V3_Drainage Report-Final_comments.pdf Markup Summary

Final Drainage Letter for Flying Horse Foundation

HR Green Project No: 2502010

SF256 & PPR 256

Updated Pond Outlet Structure Details for
Flying Horse North Filing No. 4 Pond A

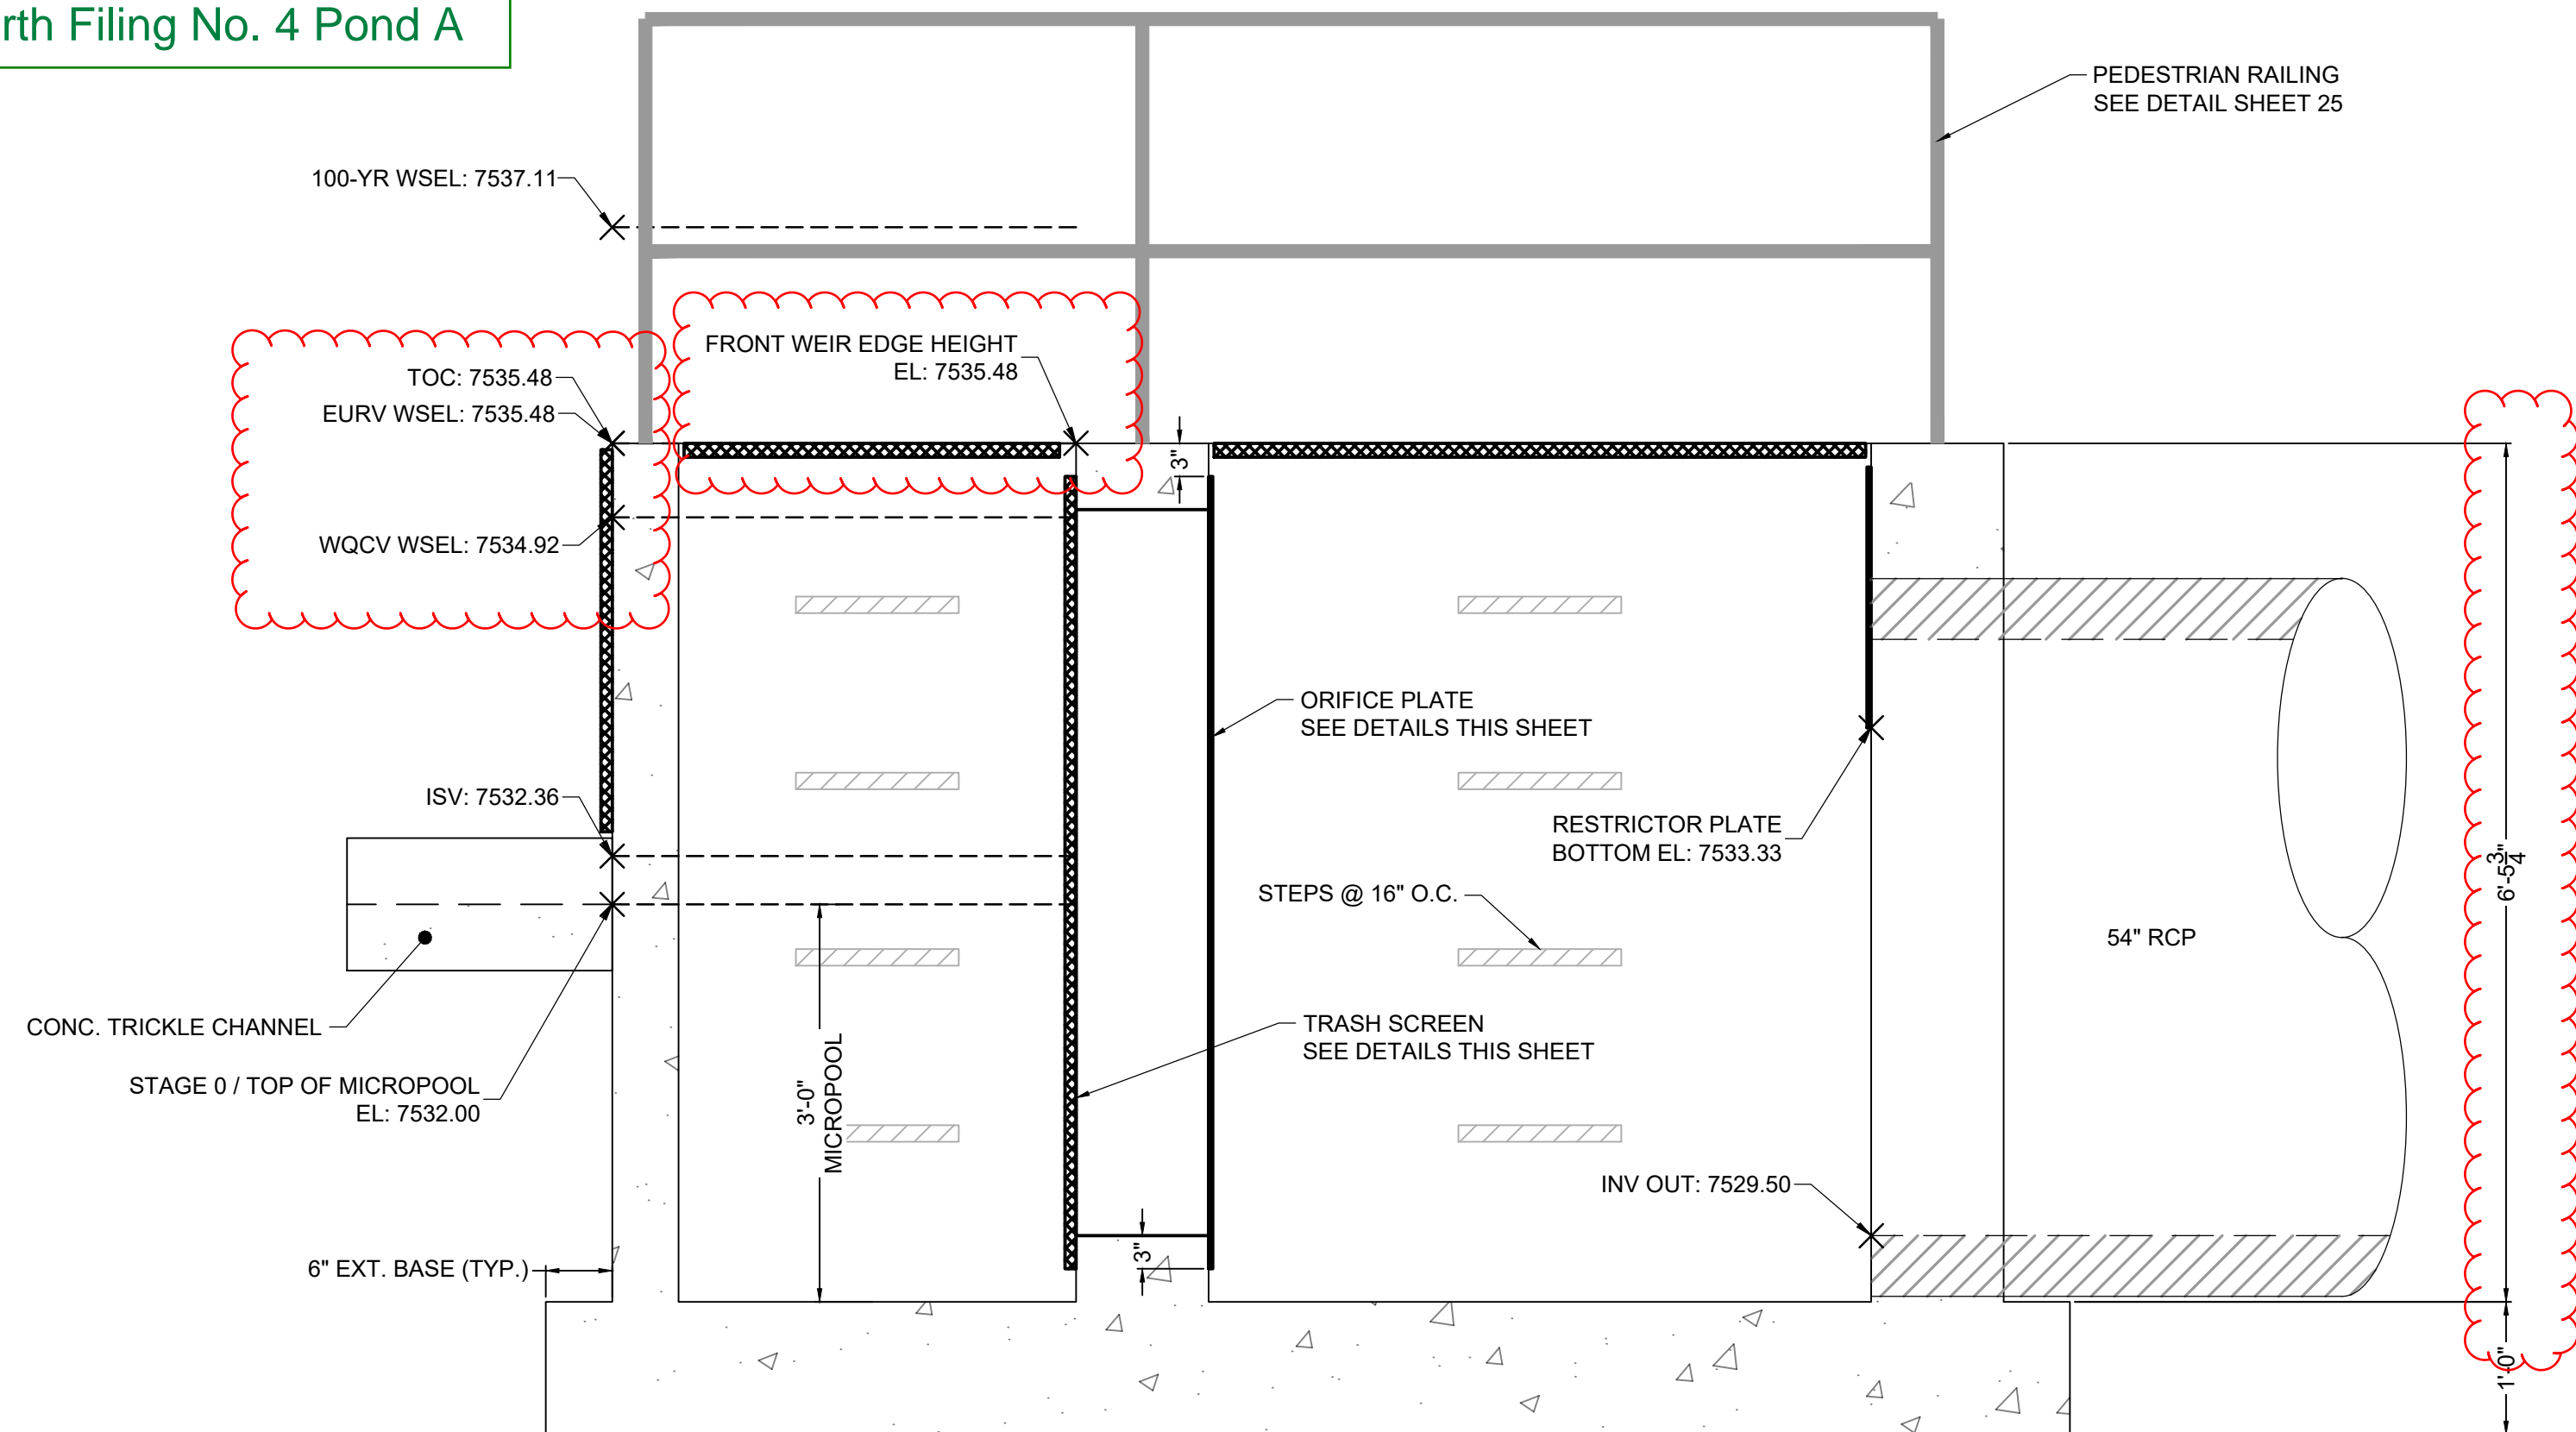
**Subject:** SW - Highlight
Page Label: 11 outlet structure height
Author: Glenn Reese - EPC Stormwater
Date: 6/25/2025 3:27:02 PM
Status:
Color: 
Layer:
Space:

**Subject:** SW - Textbox
Page Label: 52
Author: Glenn Reese - EPC Stormwater
Date: 6/25/2025 3:58:37 PM
Status:
Color: 
Layer:
Space:

For all projects, construction drawing sheets need to be uploaded to EDARP with a more appropriate document type: either with CDs or GEC plan.

So since this project doesn't have CDs, you can include these outlet structure modification sheets with the GEC Plan.

It is my understanding that the height is not actually being reconstructed, but rather it was inputted incorrectly with the original design, so that error has simply been corrected with these calcs. If true, please clarify here.
